# Rezoning Transportation Analysis

Petition Number: 2020-094

General Location Identifier: 14306126

Date	Description
08-12-2020	First Review (KP)
09-21-2020	Second Review (KP)
10-28-2020	Third Review (KP)

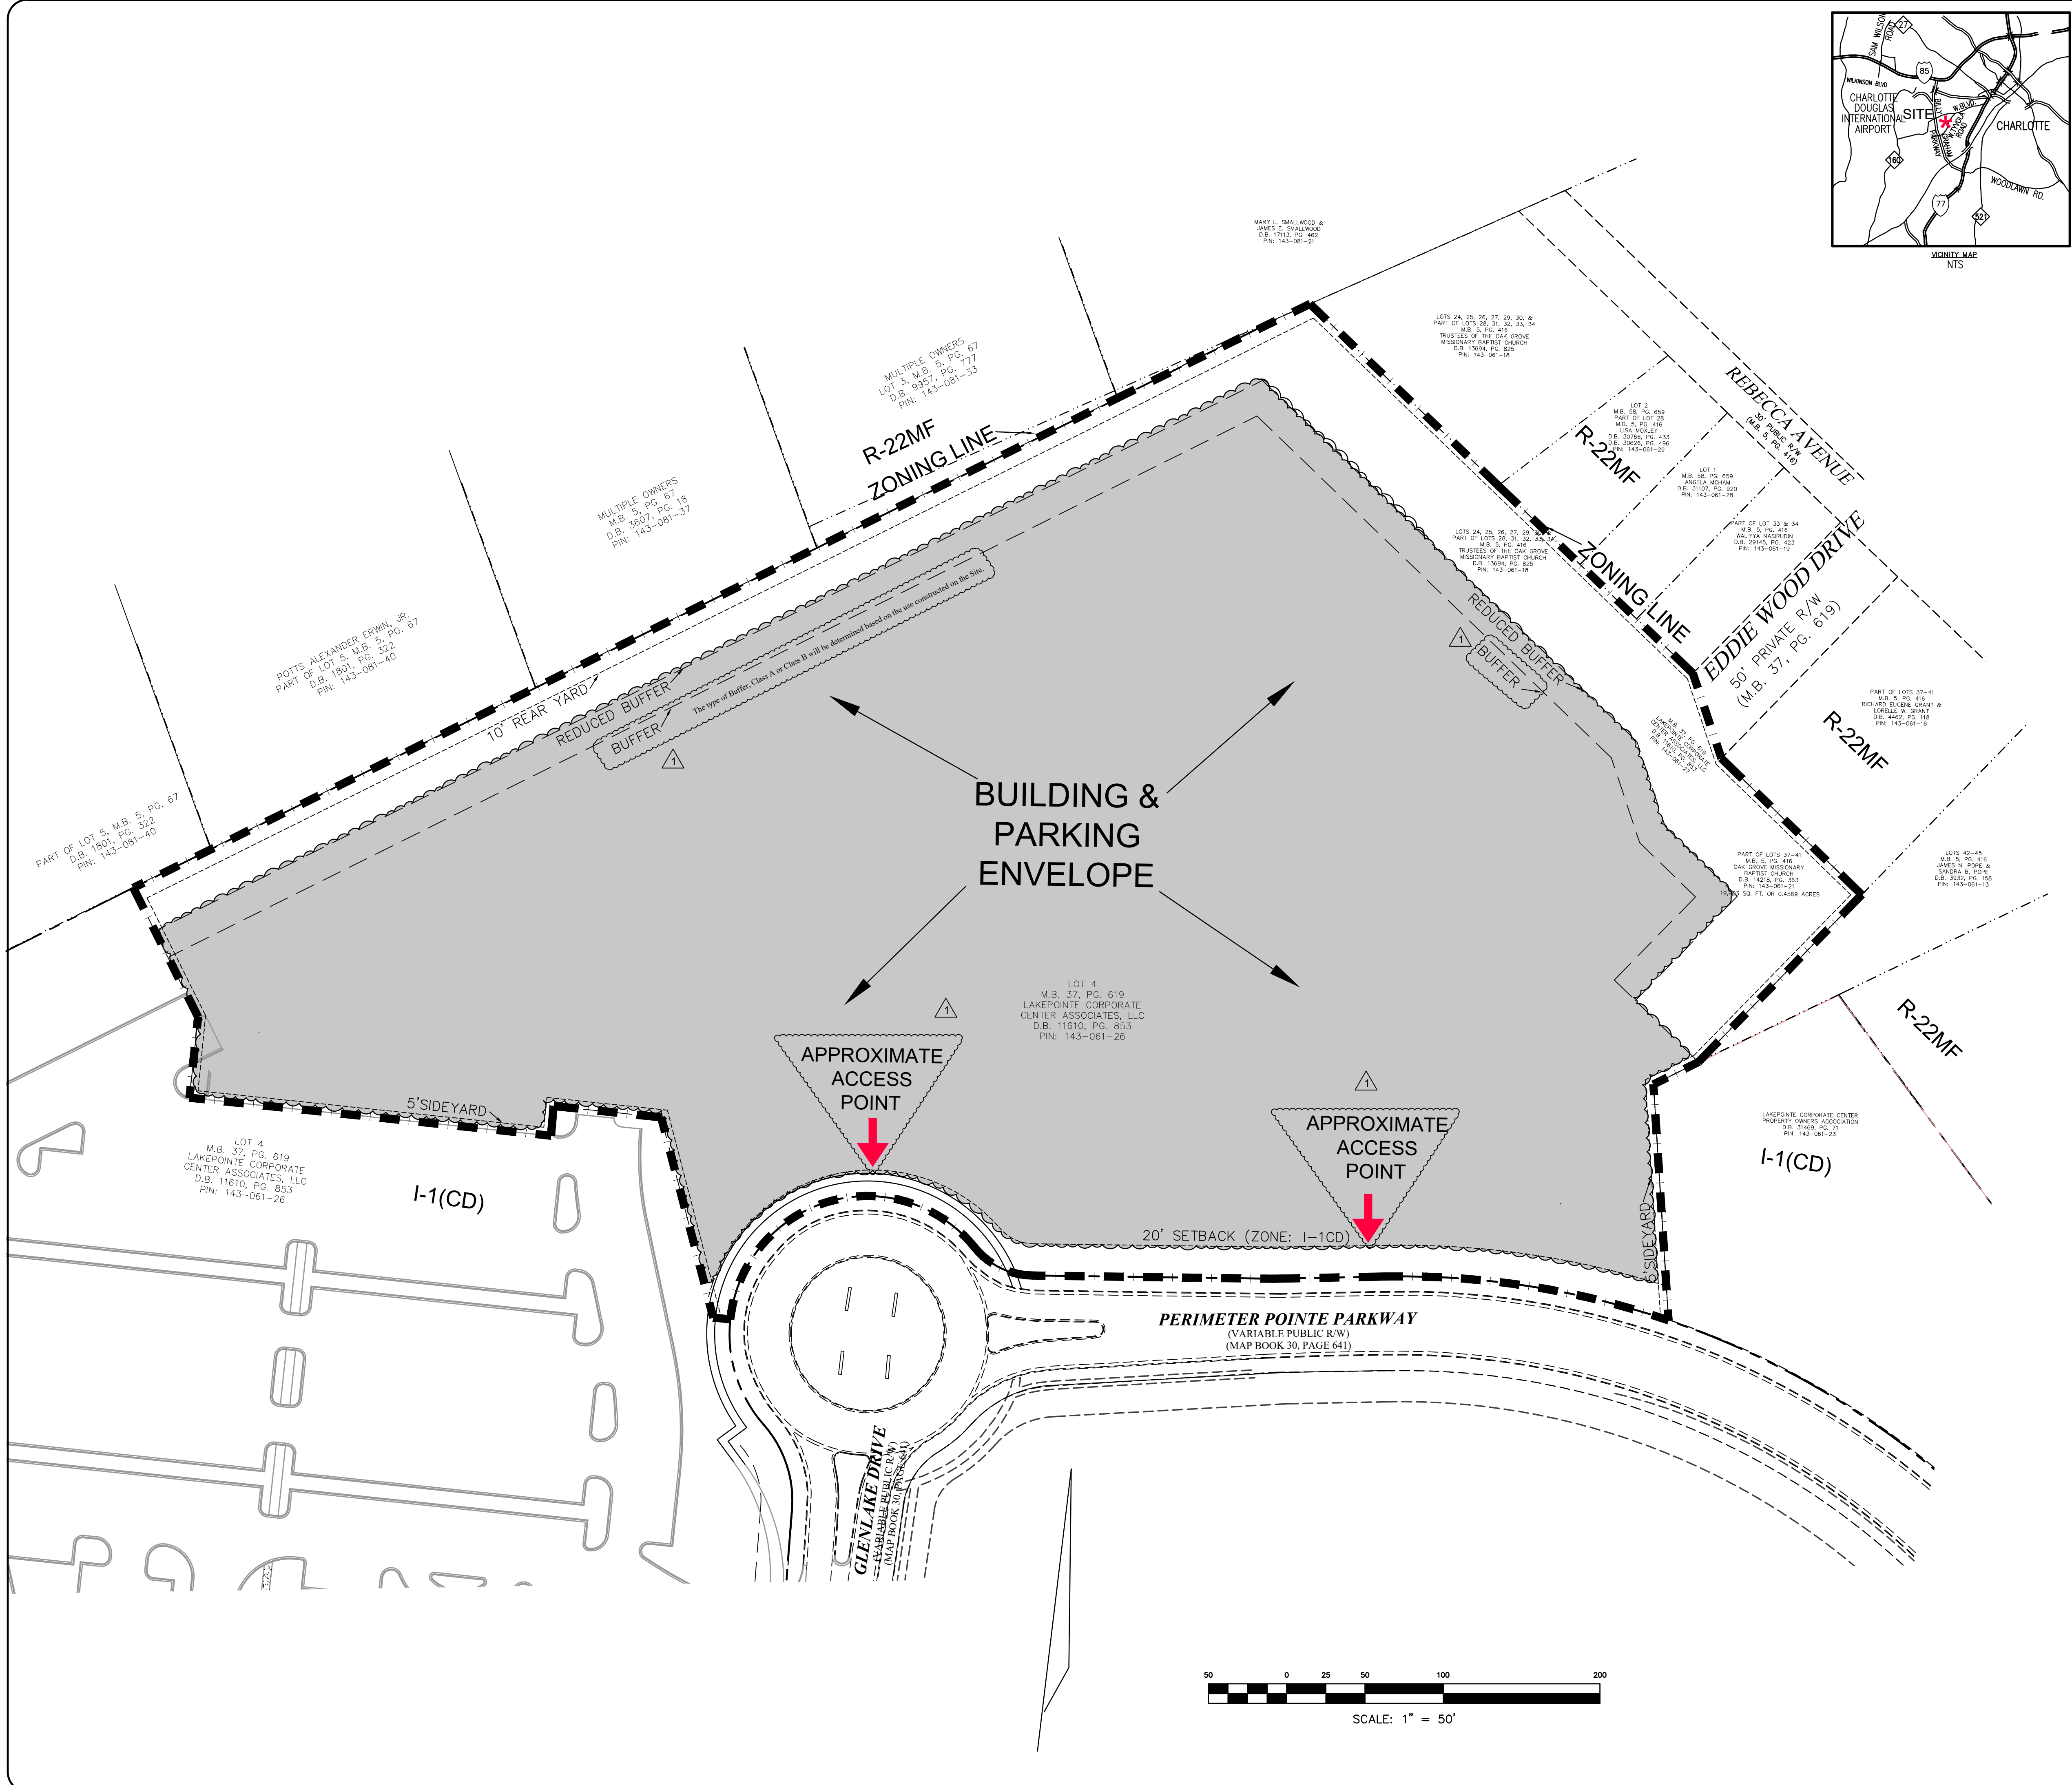
3. Revise the site plan and conditional note(s) to commit to construct an 8-ft planting strip, and 6-ft sidewalk on Perimeter Pointe Parkway as per Charlotte WALKS. This sidewalk need to tie into the existing network at the adjacent parcel, 14306125, and extend to the curb ramp at Tyvola Road. Label and dimension both items from the back of curb and gutter and road centerline.

**New Comment as a result of 10-21-20 Site Plan:** CDOT strongly suggests the 8-foot planting strip and sidewalk be extended east, along Perimeter Pointe Parkway, to the existing curb ramp at Tyvola Road. The adjacent, undeveloped, parcel is listed as common open space, in the Mecklenburg County Tax Records, for the Lake Pointe Corporate Center and is not subject to further development.
